Application No: Y/48/21/PL
Site Address: Land south of Ford Lane East of North End Road Yapton BN18 0DS
Description of works: Construction of temporary vehicular access off North End Road for three years to allow safe access to the affordable units throughout the remaining period of construction within the application site following Y/82/20/RES. This site is in CIL Zones 2 & 3 (Zero Rated) as other development.

Thank you for your internet representation made on 19th May 2021 which has been recorded as support with the comments as follows:

YPC has fully considered this application and has concerns relating to an access point in this location. However, YPC appreciate the need for efficient site management during a building programme and therefore support on the basis of the following conditions being applied should approval be consented:

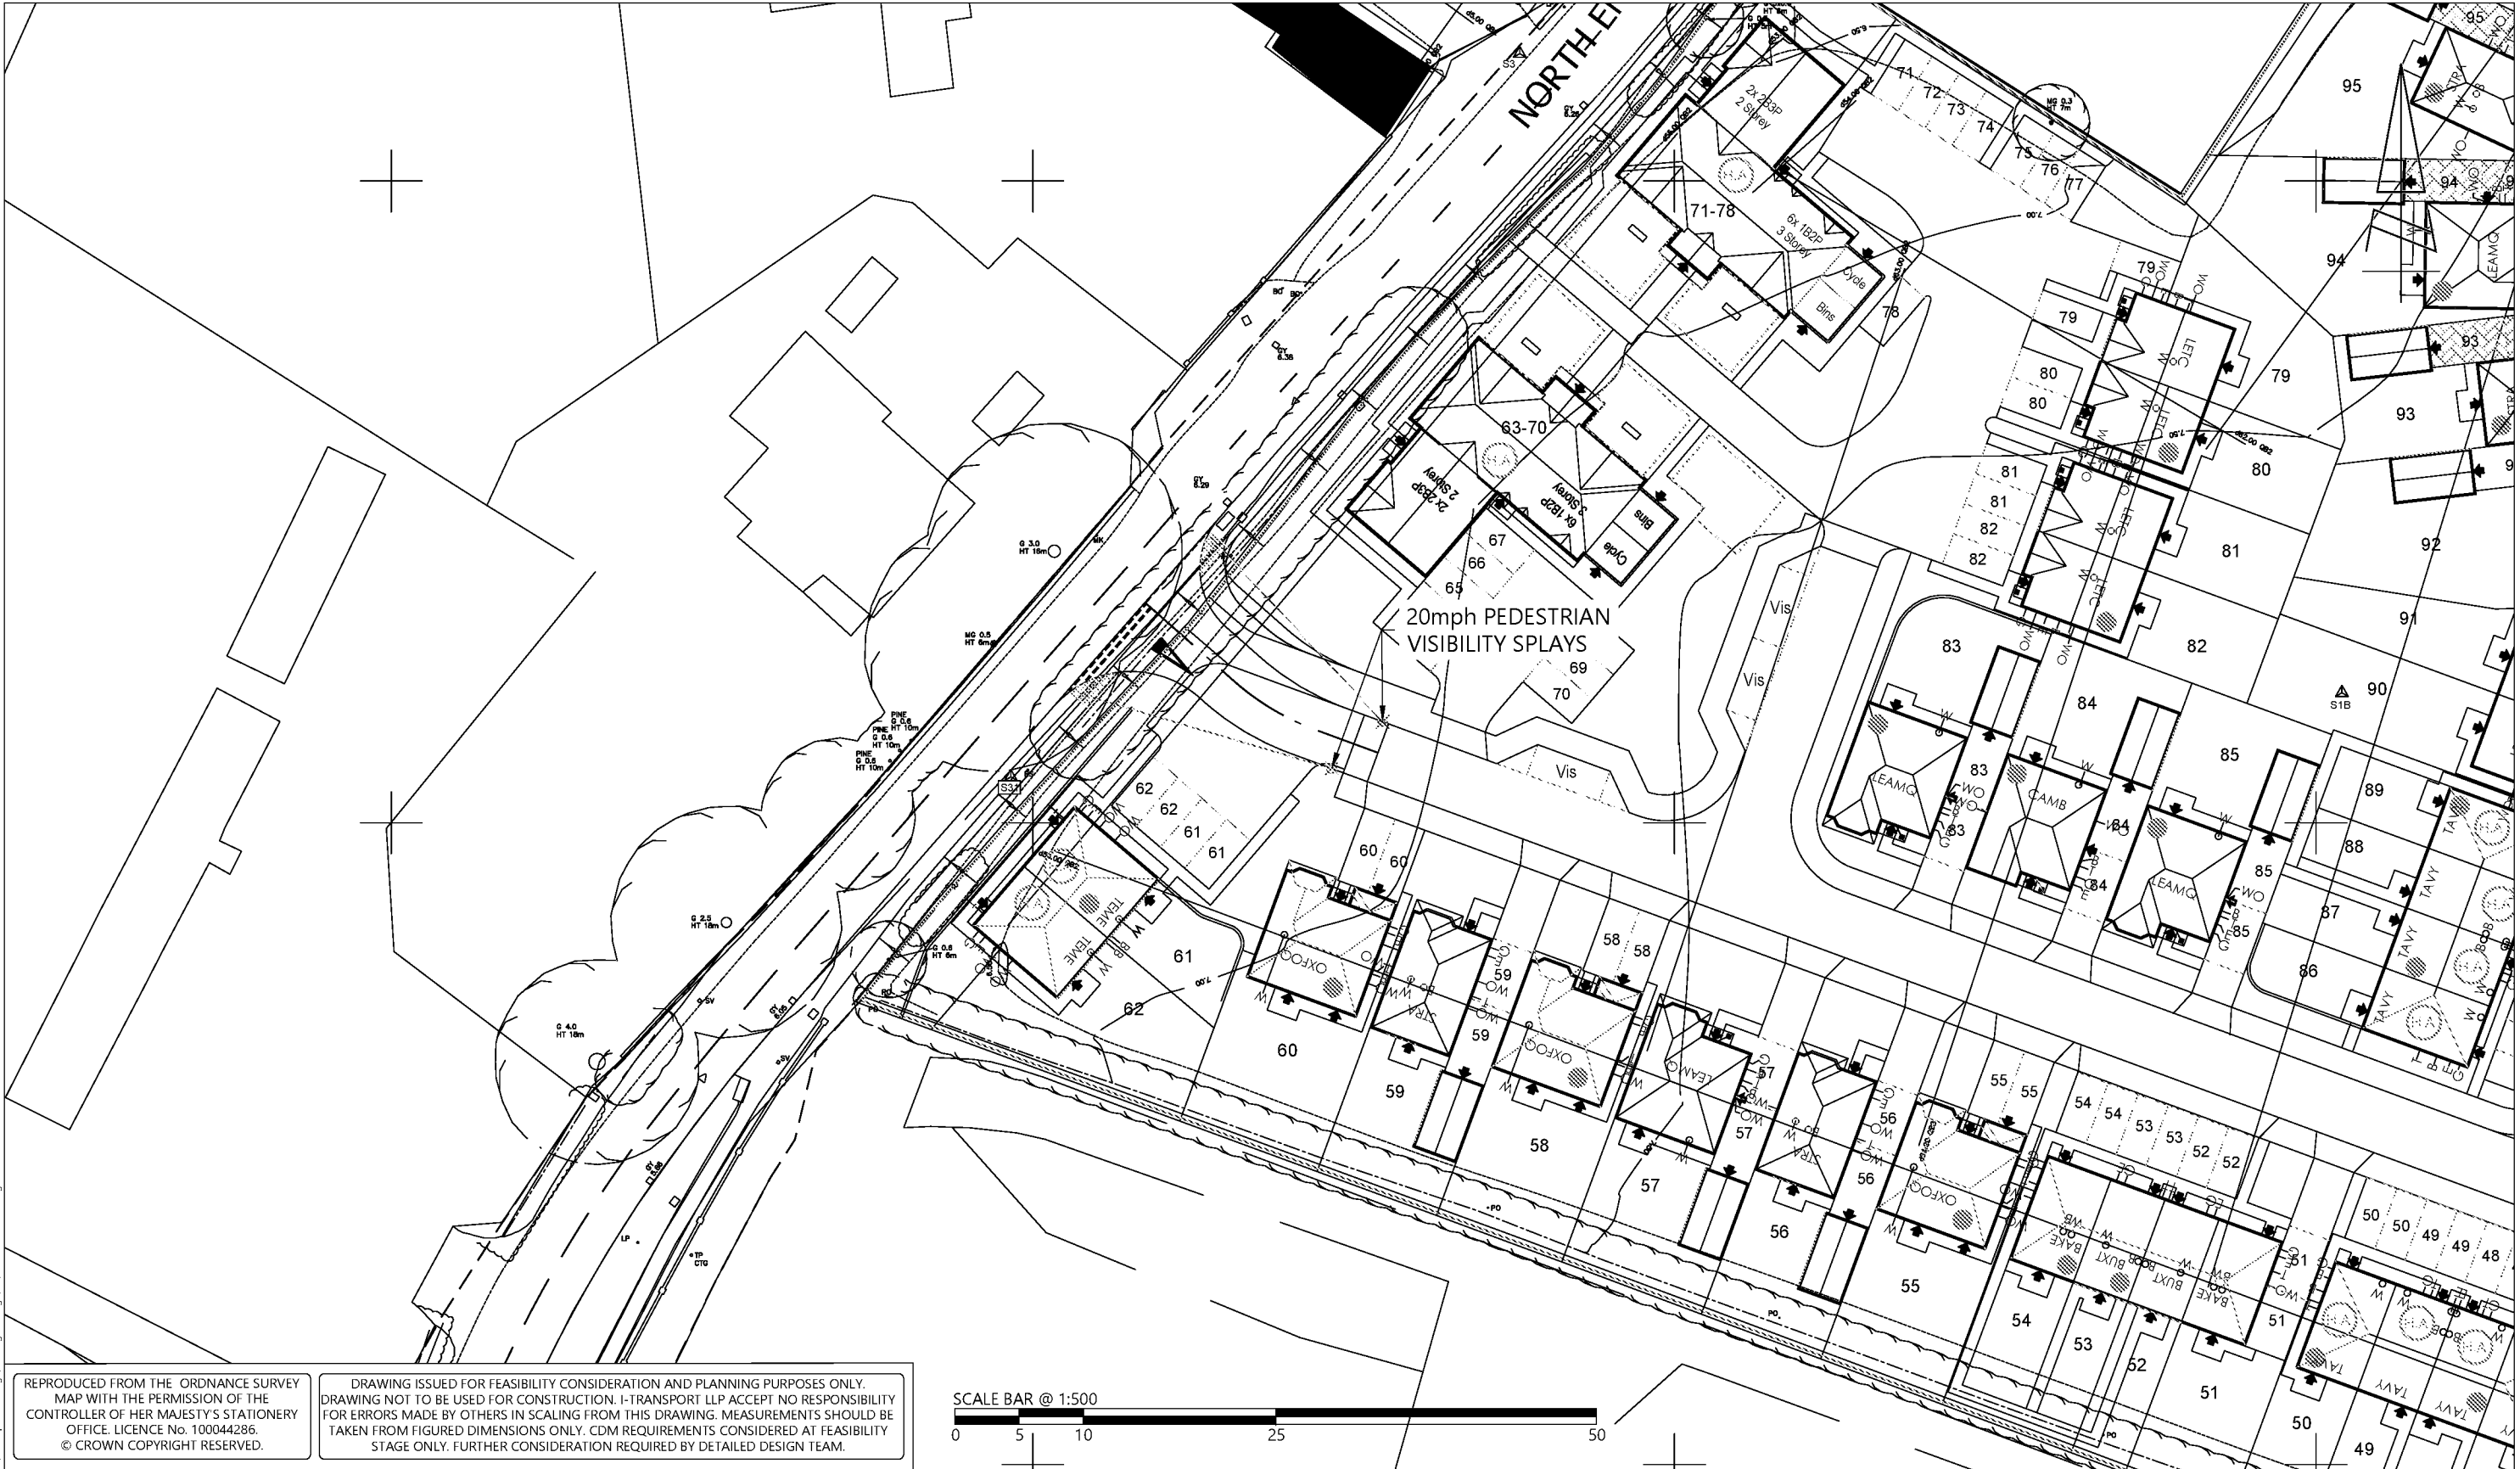
- The temporary access is for private vehicles only excepting waste collection and emergency service vehicles. At no time can this access point be used for any construction vehicles or deliveries relating to the construction programme. This is to ensure the safety of pedestrians using the pavement especially school children during school run times.

- This temporary access must be permanently closed off with raised kerbing reinstated securing the reinstatement of the pavement once this temporary planning period has expired or the last unit has been occupied whichever is the earlier. To ensure that pedestrian safety is paramount, and that the temporary planning status is not exploited.

- At all times the applicant must ensure safe pedestrian crossing point along this section of the pavement to ensure full and safe use by pedestrians especially school children going to school. Crossing must be sufficient for both wheelchair and double buggy use.
